Response to Agency Submissions

Issue	Details	Response
City of Sydney		
Affordable Housing Contribution	<p>The applicant has stated Development contributions equivalent to 2% of the development cost will be paid in accordance with the Redfern Waterloo Contributions Plan 2006, which is supported by the City.</p> <p>However, despite the proponent acknowledging that the Redfern-Waterloo Authority Affordable Housing Contributions Plan 2006 applies to the site, they are seeking an exemption as the “proposed development meets the objectives of the Plan.”</p> <p>The City objects to the exemption request and recommends the affordable housing levy be applied for the following reasons:</p> <ul style="list-style-type: none"> • The proposed development is not one of the types of development to which the plan does not apply, and • The Plan does not provide an alternative pathway for exemptions beyond those described in Clause 6 of the Plan. Any exemption would be inconsistent with the Plan. 	<p>The Applicant is no longer seeking an exemption from affordable housing contributions. Refer to Section to 3.20 of RTS report.</p>

6 DDA Single Studio 1 : 50

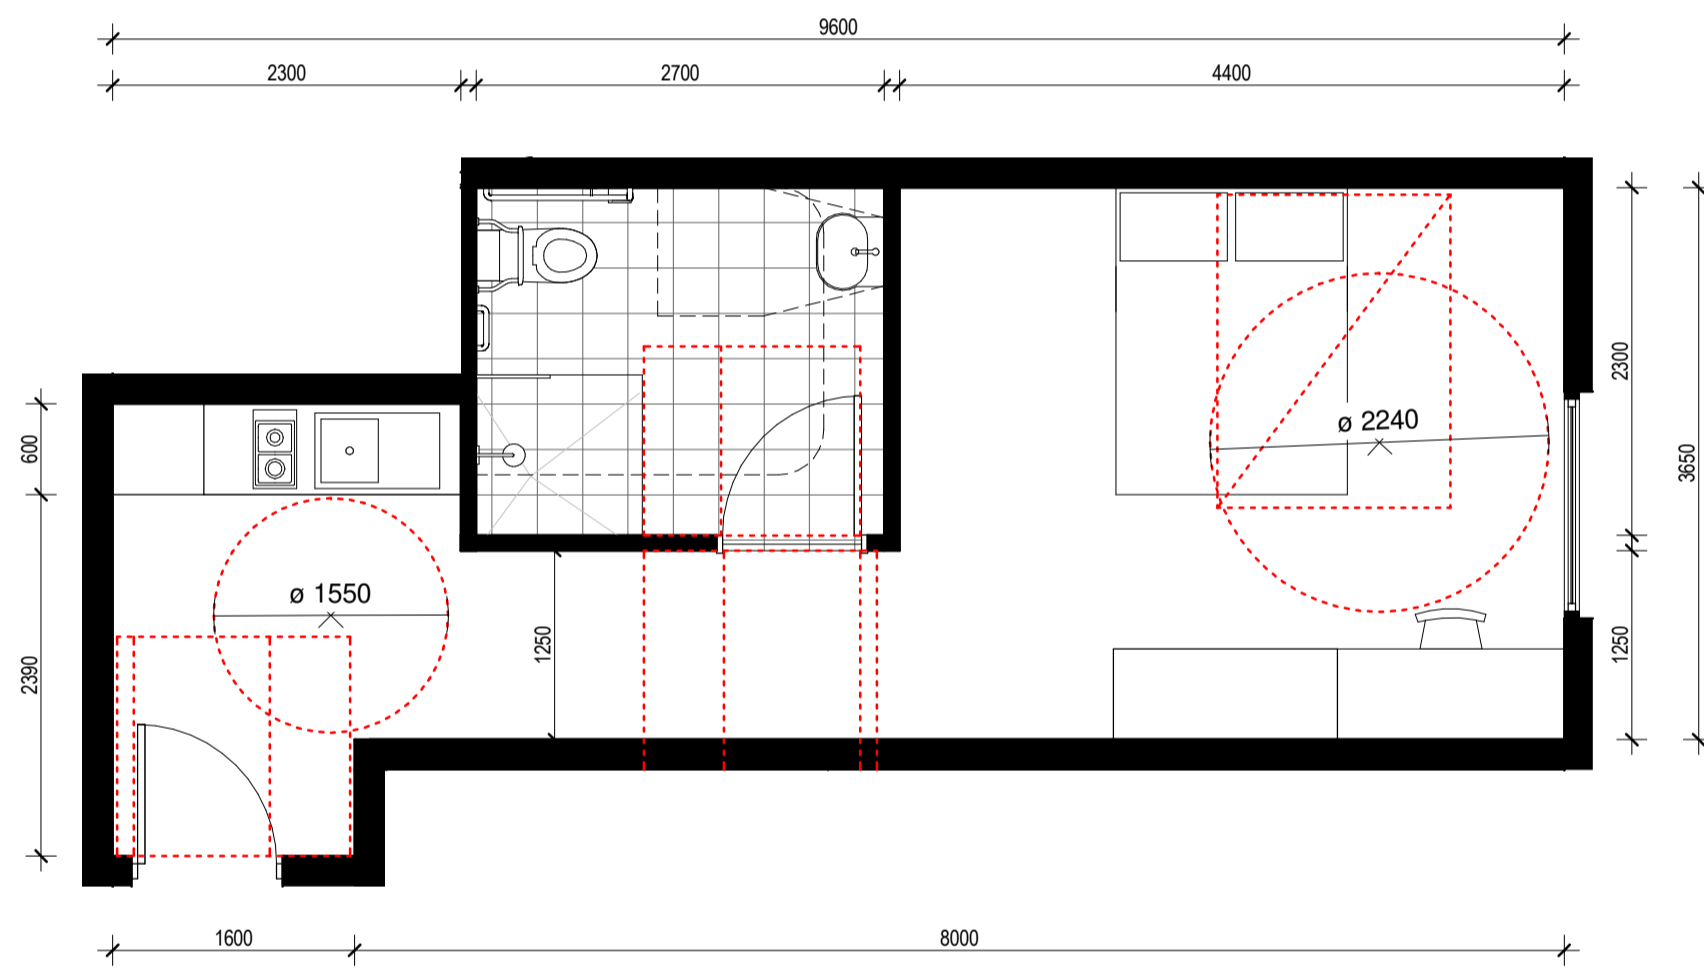
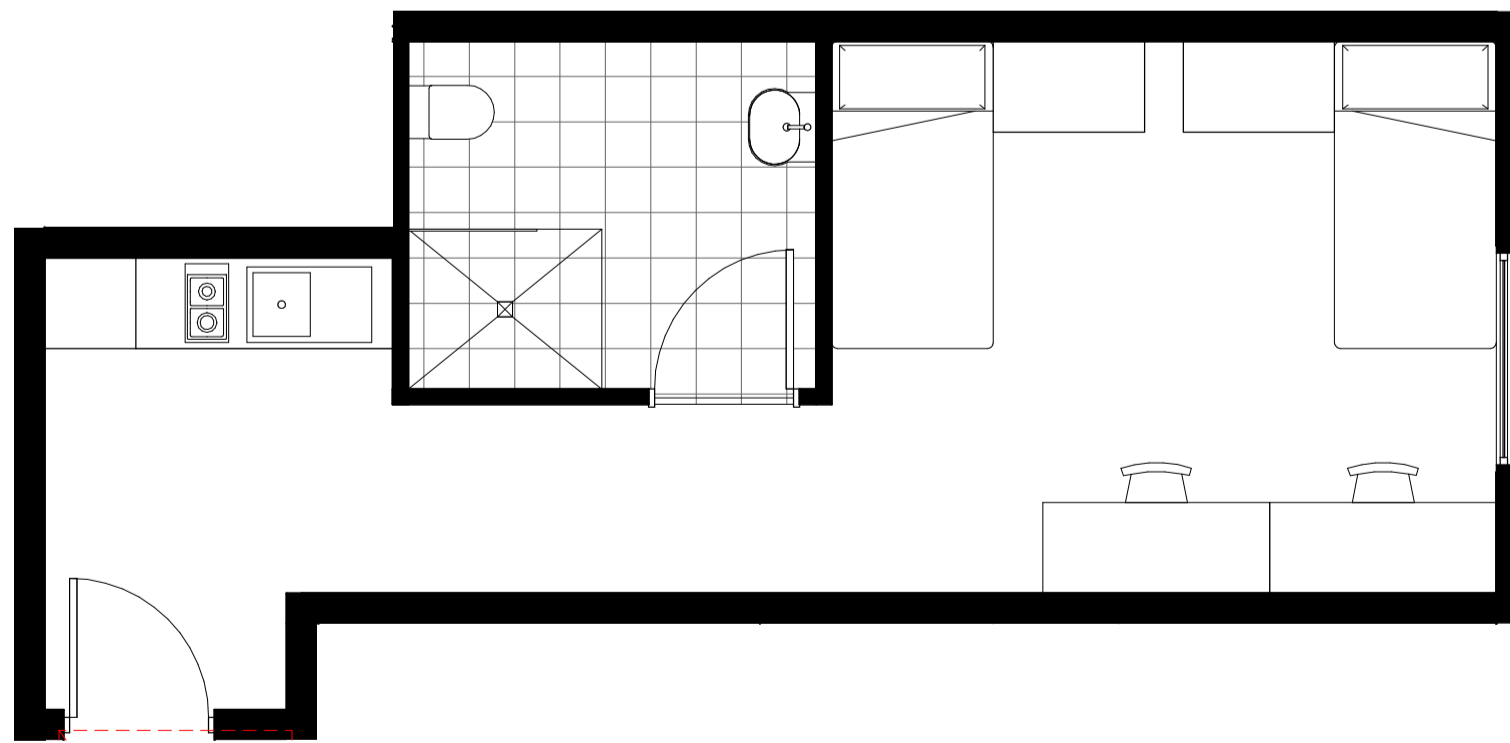
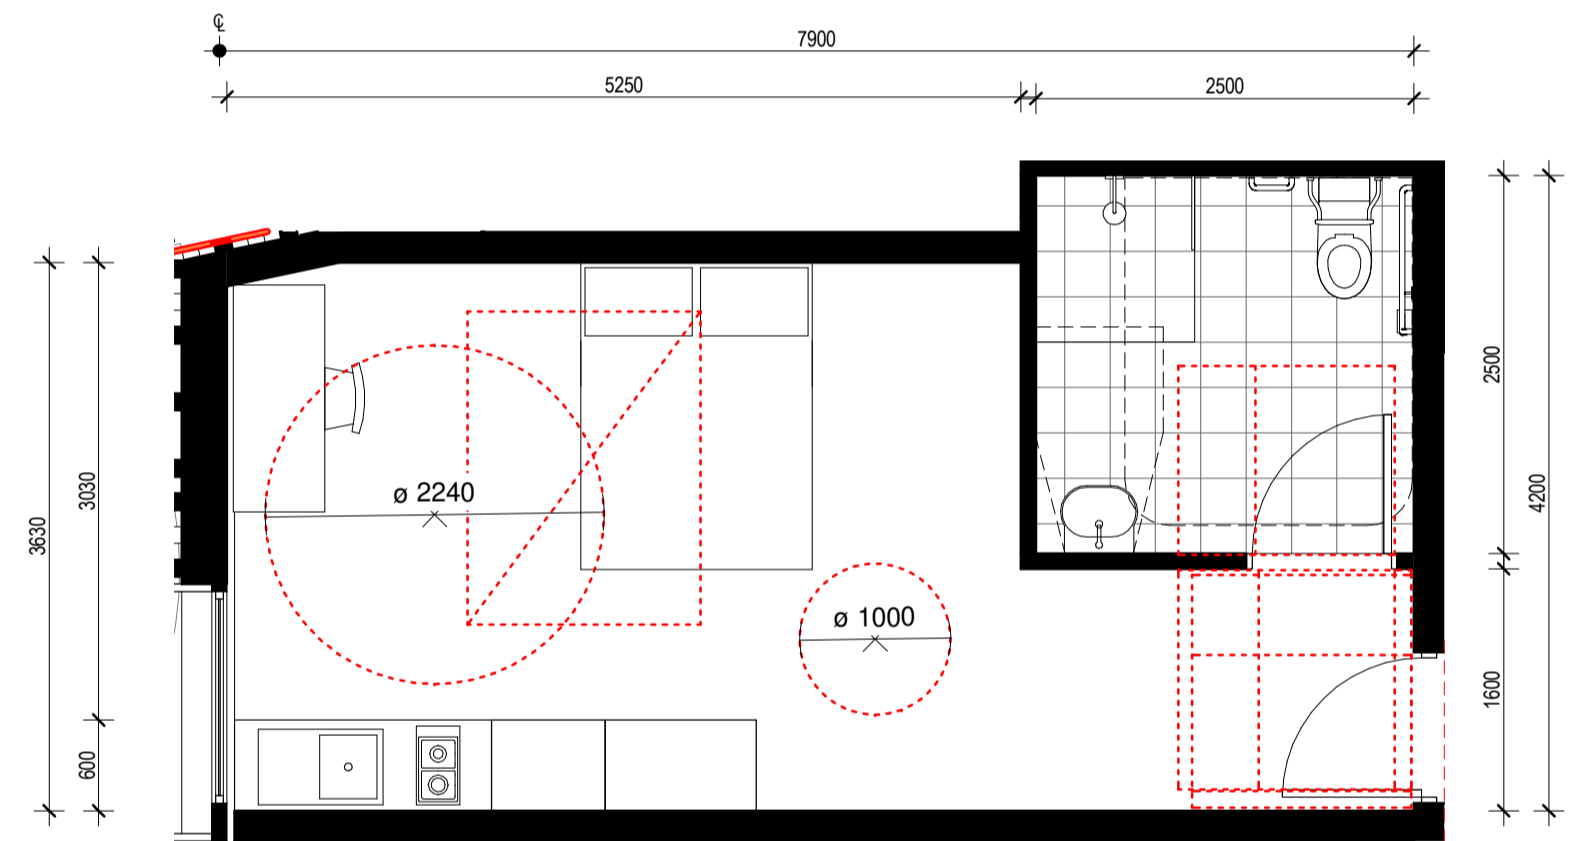
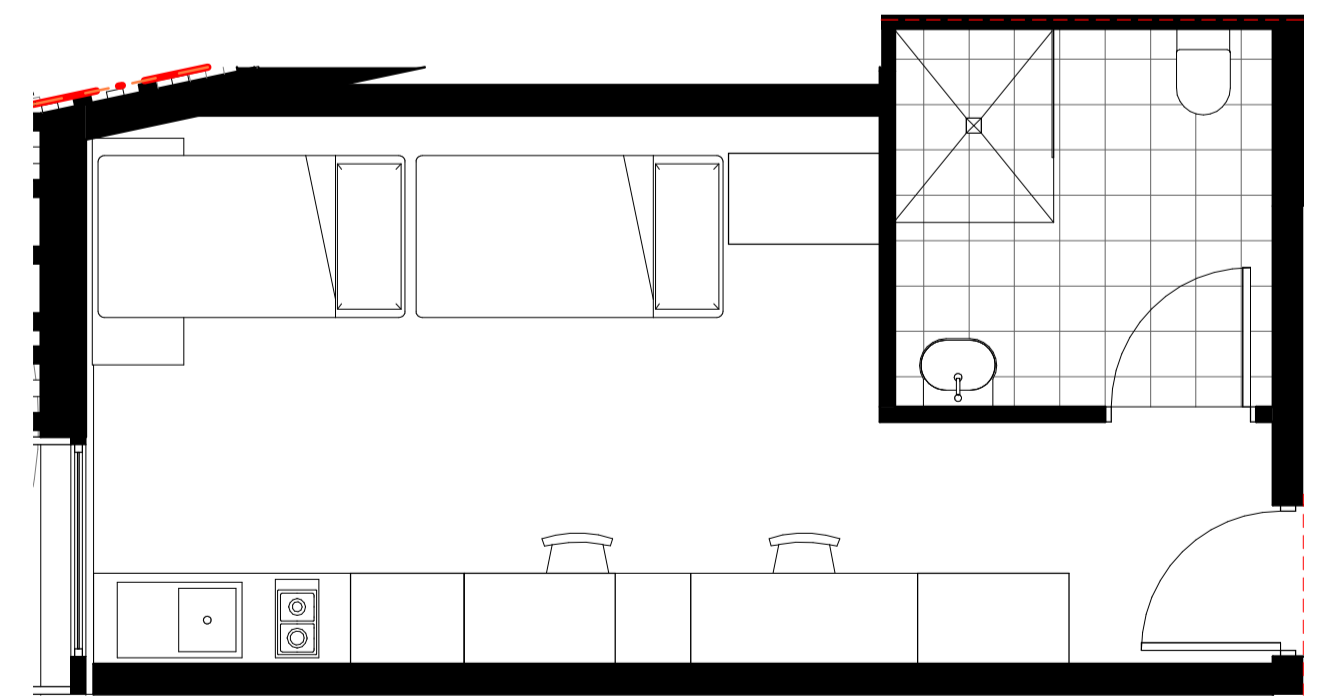
Accessibility	<p>At the main Gibbons Street entry, the accessible ramp is poorly integrated into the design of the entry. The ramp is tucked behind a wall which reduces its visibility, and the dog-leg form of the ramp is circuitous. A better design would start and finish the ramp much closer to the non-accessible route, providing a more dignified and equitable means of entry.</p>	<p>The main entry, including the access ramp, has been redesigned to provide an improved and simpler access route for all persons. Accessible access has also been provided to the eastern entrance at the TSL. Refer to plan DA2001.</p>
